From: Ross Anderson <rossa@acarchitect.com>
Sent: Wednesday, December 30, 2015 11:53 AM
To: Jeff Watson
Cc: cruseandassoc@kvalley.com
Subject: RE: BL-15-00016 Anderson
Attachments: BL-15-00016 Anderson Site Plan with Mark-Up.pdf

Subject: BL-15-00016 Anderson

I have received comments from all required departments, reviewed the file in detail, and need clarification on one point. The site plan provided does not appear to portray the garage/storage structure west of the house. If in fact the structure still exists, it appears to me that proposed western property line may not provide for the ten foot rear property line setback required in the Forest and Range zone (it's hard for me to tell but it appears the proposed line may dissect the garage footprint). Even if the garage is entirely inside large parcel it is likely it will not meet the required 25 foot setback for a front property line in Forest and Range. Could you please clarify and/or provide a revised site plan depicting the location of the garage which indicates that all setbacks for the zoning will be respected.

This Proposed Property Line

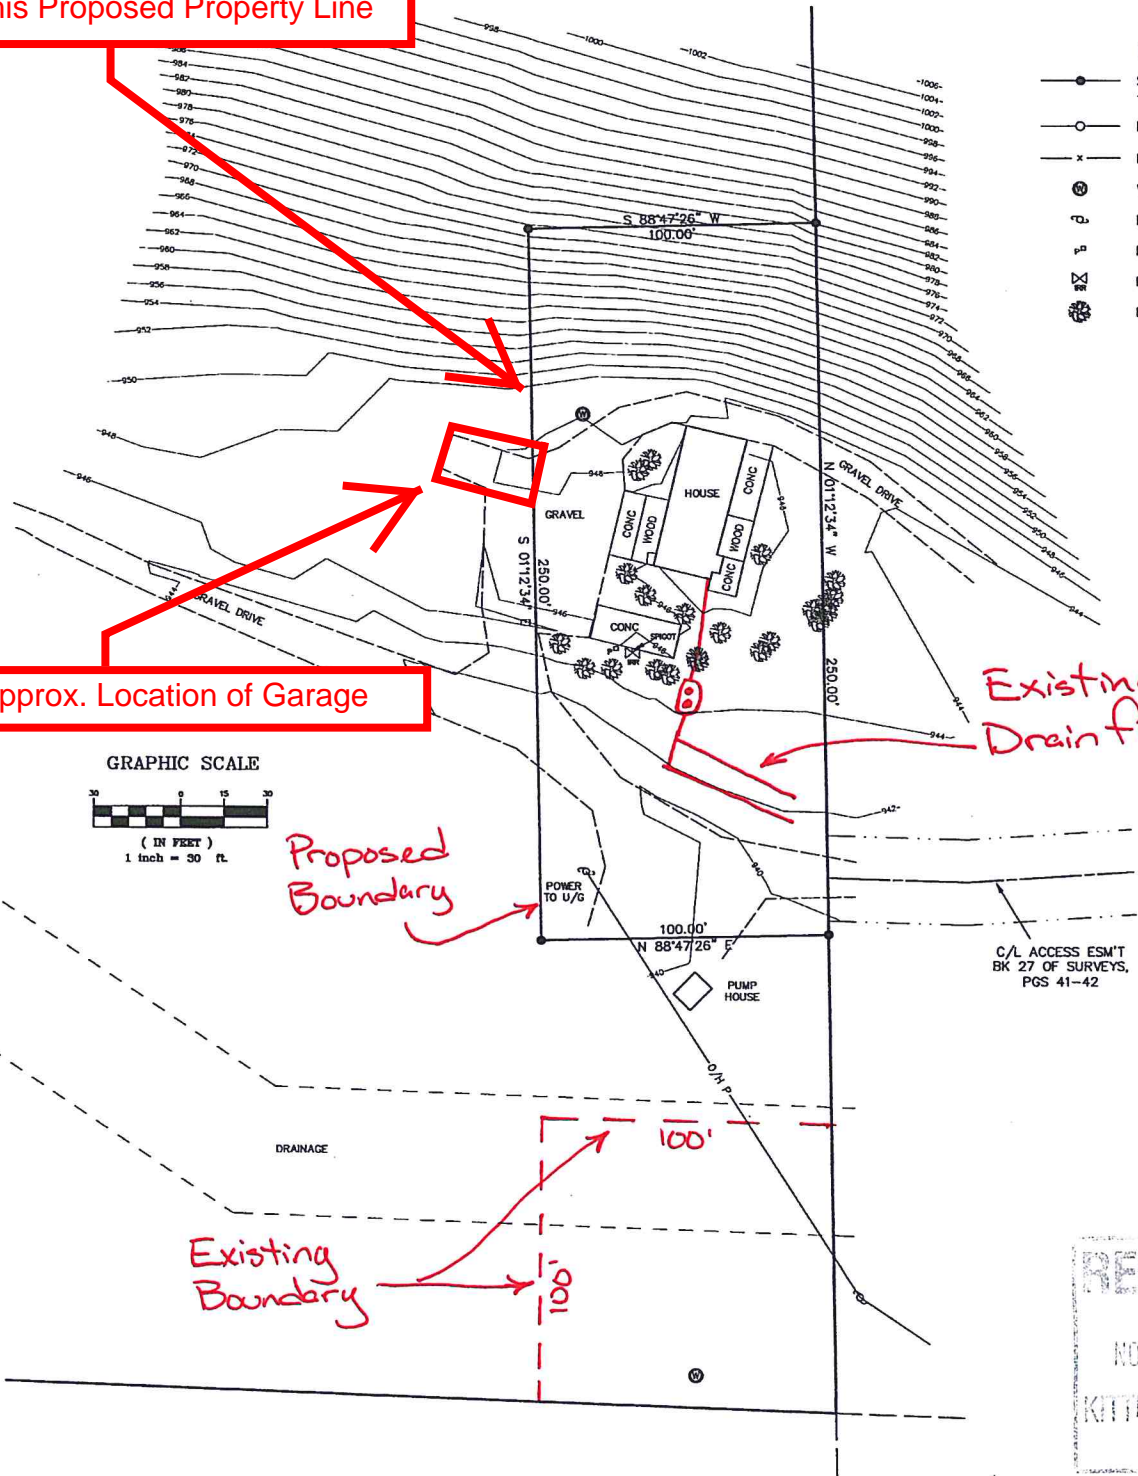
Yes this is my property with the BLA from Cruse. Where you show "approximate location of garage", that does not exist. Three storage outbuildings did exist there but they burnt down 2 summers ago. I will be constructing, I hope, further to the west a new garage/Residence structure. The new construction will meet all required setbacks.
